Our ref: DOC19/531175  
Your ref: SSD-7308

**Subject: EES comments on Notice of exhibition – St Marys Intermodal, Forrester Road, St Marys – construction and operation of intermodal terminal and container park – SSD-7308**

**EES comments on Notice of Exhibition - St Marys Intermodal, Forrester Road, St Marys – construction and operation of intermodal terminal and container park - SSD-7308**

Drawing Name:
Landscape Plan

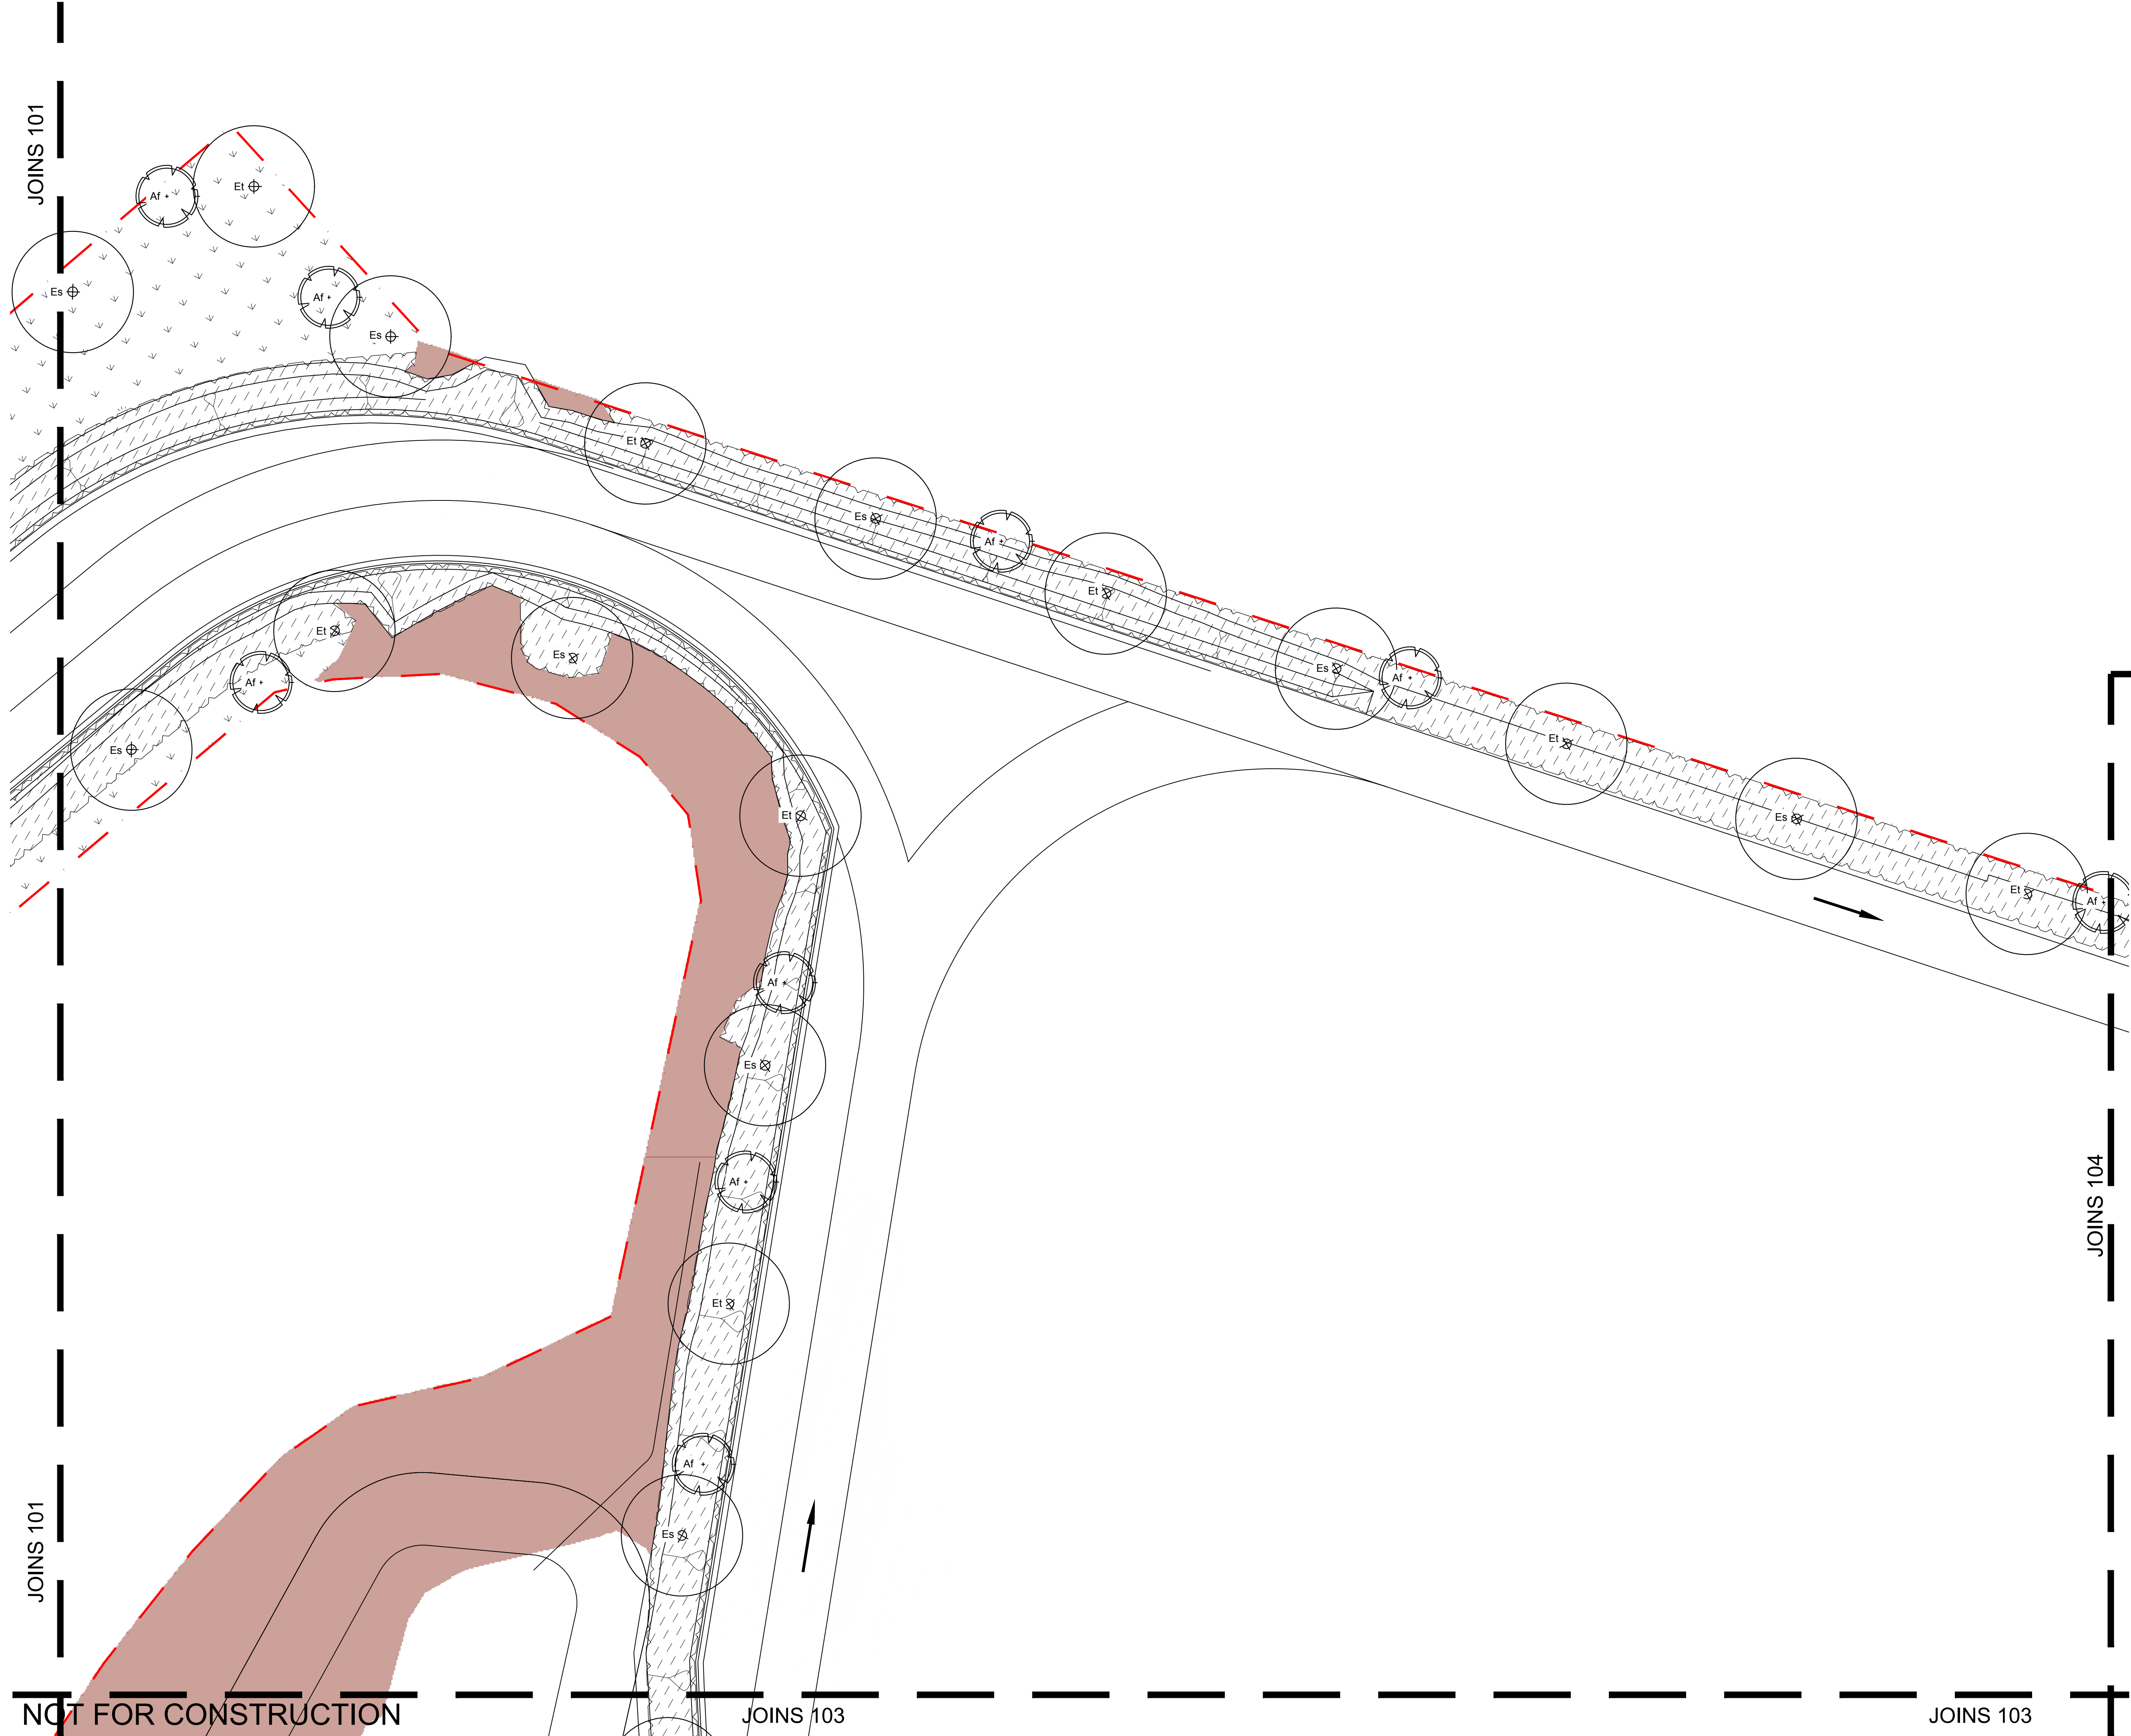
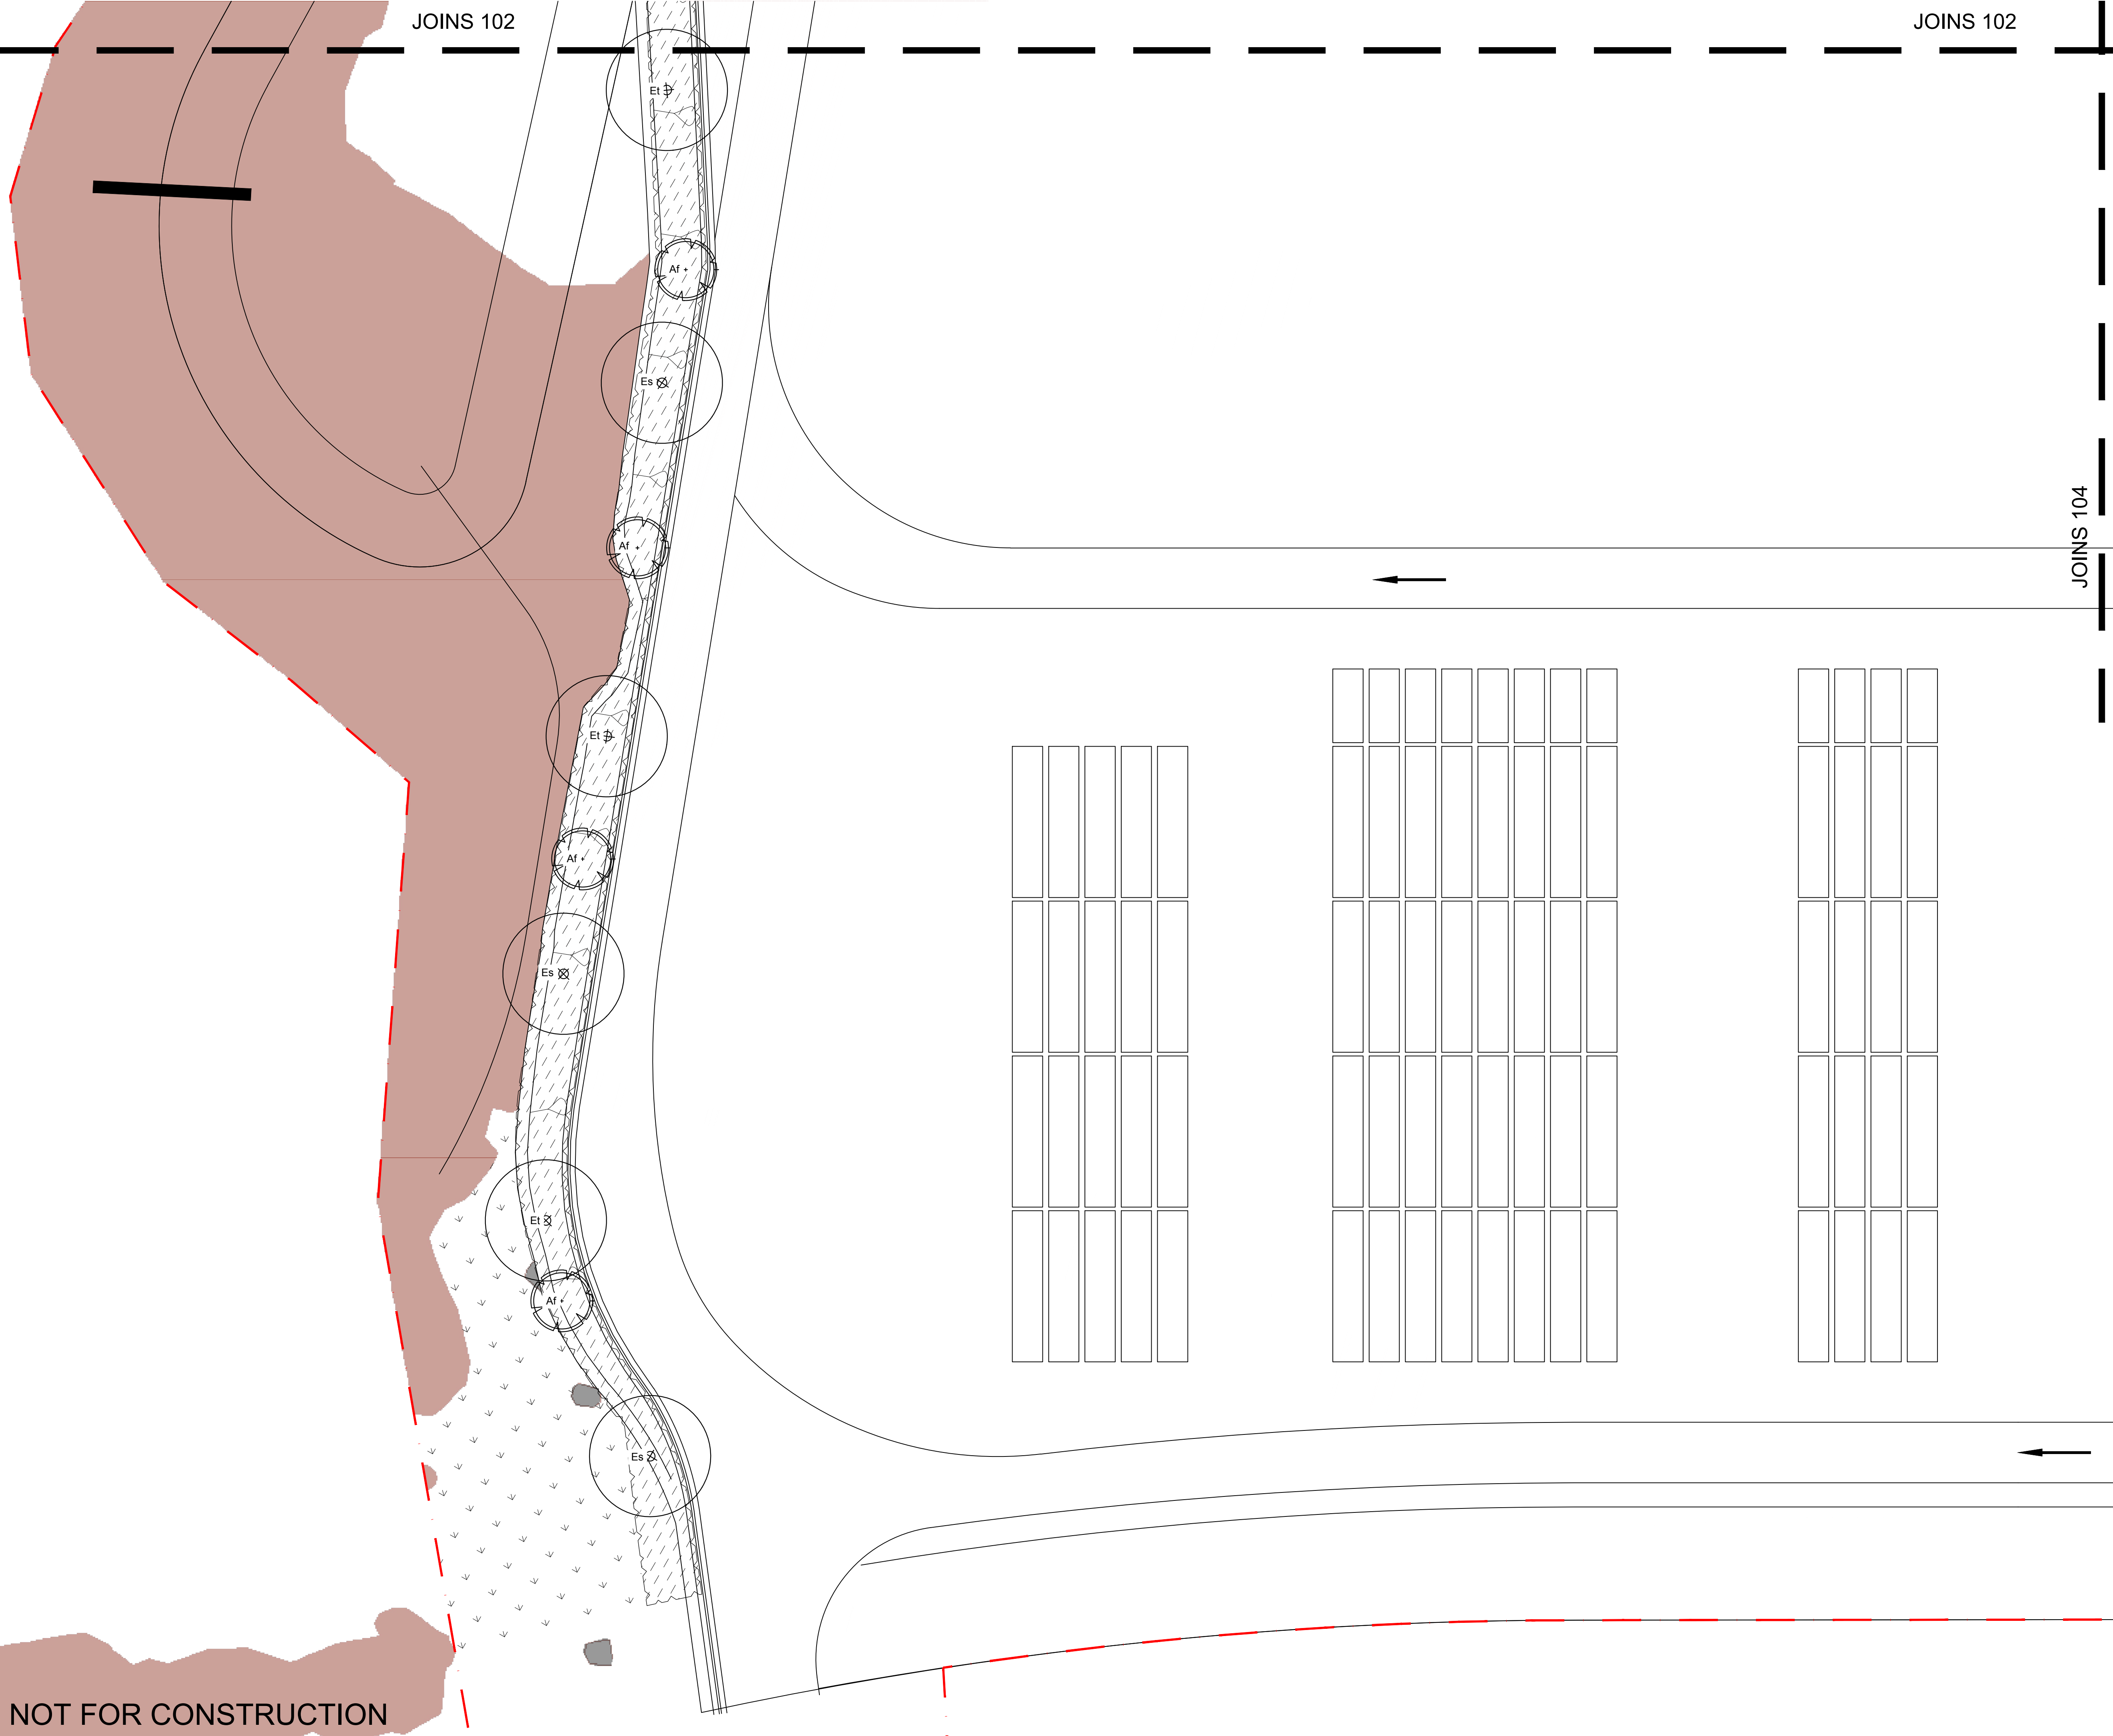
- Table 26 includes recommendation that a vegetation management plan is prepared to protect and enhance retained vegetation. This is supported by OEH, particularly given the areas of retained vegetation are so small, that without active management they are unlikely to persist in the long term. However, the species to be planted in these areas and adjacent to these areas should be appropriate for the vegetation type. The EIS states that "The landscape design has adopted endemic species from the Mitchell Landscapes. Hawkesbury-Nepean Channel to complement the existing native vegetation being retained onsite". OEH recommends that the species to be planted should be derived from species lists for the relevant Plant Community Type, using Figure 3 of the BDAR as a guide. Plants should be sourced from locally endemic provenance material.
